FW: LU/196/26/CLP- 11 Sandfield Avenue, Littlehampton

I am the case officer for the above application and have done an initial review. Please could you provide a section drawing? From the submitted plans, it is not clear what the proposed eaves height would be.

Drawn by	SW	DRAWING NUMBER	REV
Checked by	SR	P 3

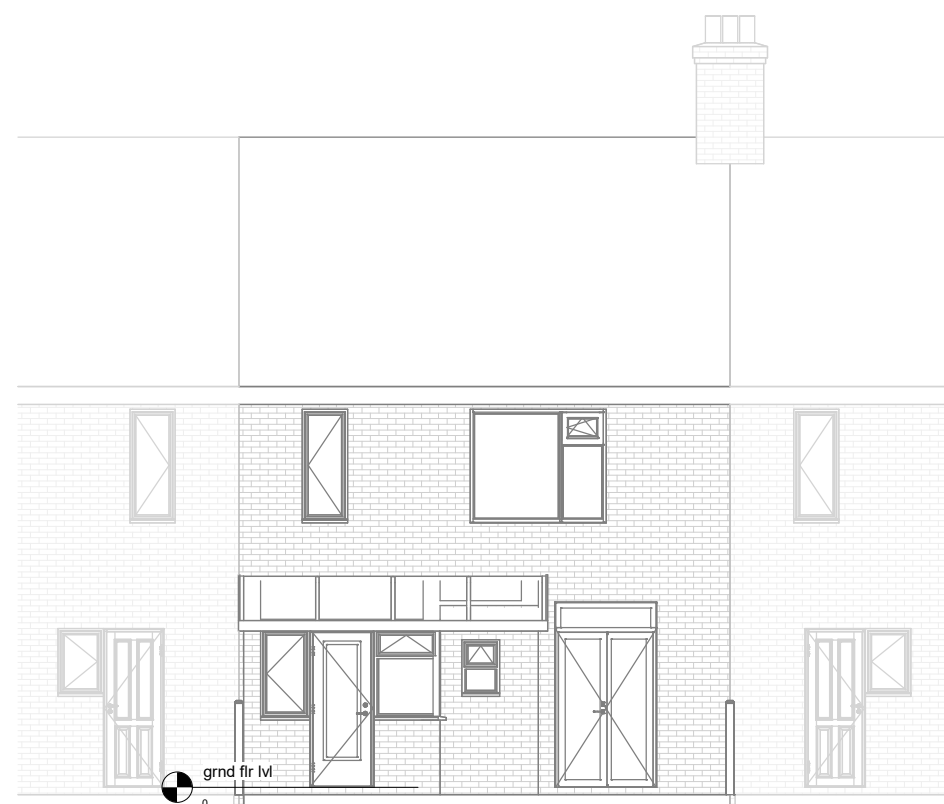
I requested sections drawings as it appeared there was a parapet and I wanted to make sure I can measure the height correctly.

Please find attached the required section on page p3 as requested
